WELLINGTON AEROCLUB INC.

31 July 2012

The members of the Wellington Aero Club Inc. wish to object strongly to the plan to install wind turbines within the vicinity of the Wellington aerodrome. The Preliminary Environmental Assessment for the Bodangora Wind Farm (MP 10_0157) states the proposed wind farm will be 3km from the Wellington aerodrome. This is much too close for safety.

FIGURE 9: Proposed Wind Farm Layout

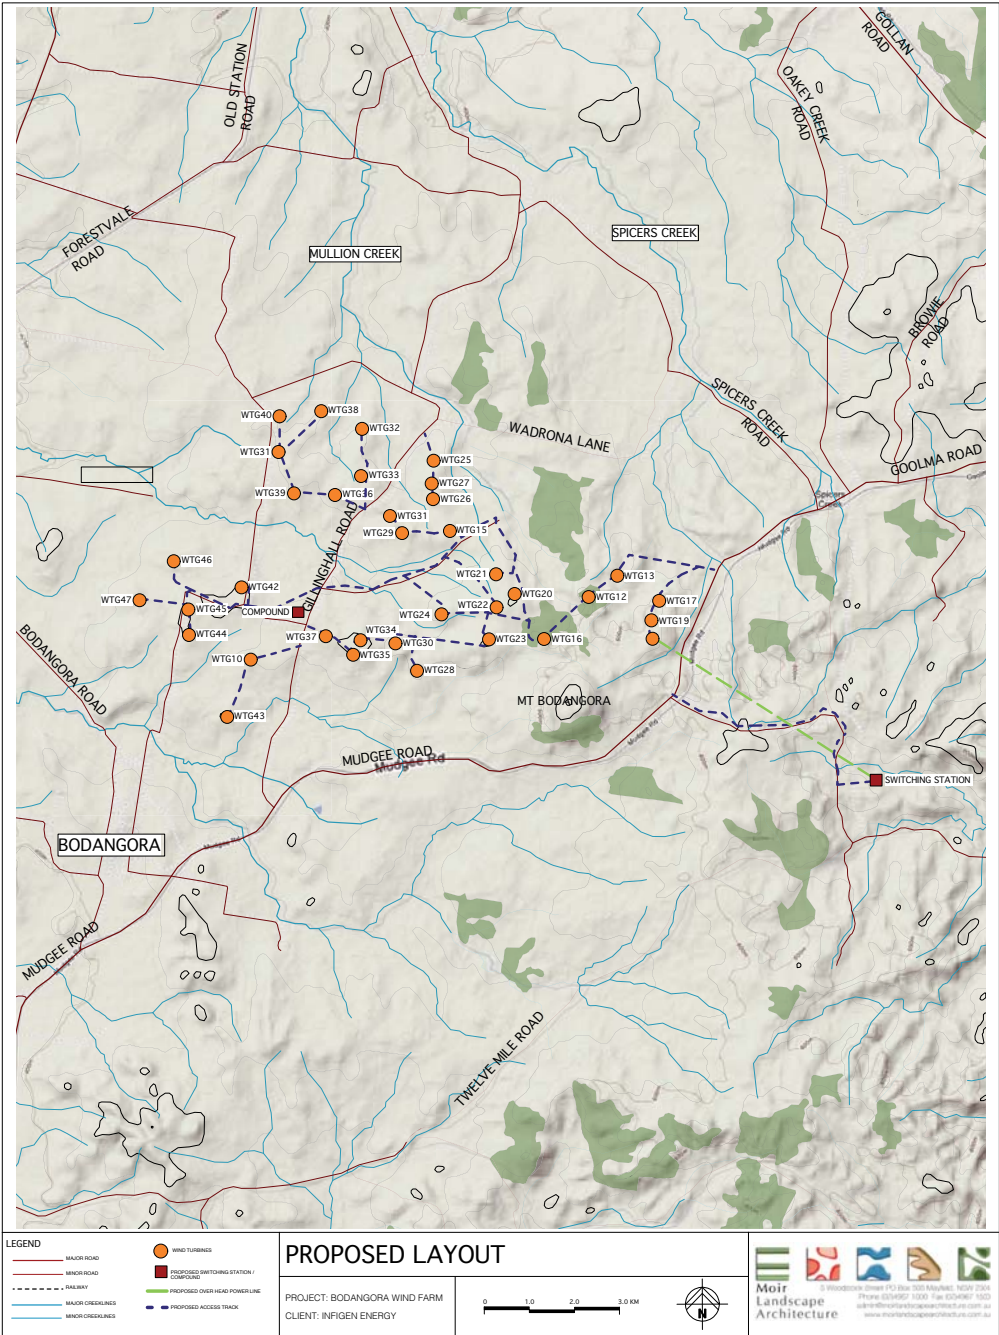
Firebombing aircraft are going to have problems clearing the towers when taking off loaded, as their rate of climb to the east may be insufficient to clear the towers that are planned to be on the higher ground in this direction.

- The Wellington Airfield is not on the Western border, it is south west of the proposed wind farm development.
- The runway is stated to be north-south. This is incorrect. The 05-23 runway is slightly more easterly than north-east which means aircraft using this runway would be flying through the tower area only 3Km from the runway. This would cause extreme danger to pilots and passengers.
- The other runway is 13-31 which is slightly more easterly than south east, again bringing aircraft into conflict with the towers during takeoff and landing procedures.
- The Wellington aerodrome was opened long before 2006. It was the extension to the 13-31 runway that was opened in 2006. Although this point does not aid misinterpretation of the dangers of the towers to aircraft, it shows the poor attention to the facts in the report.
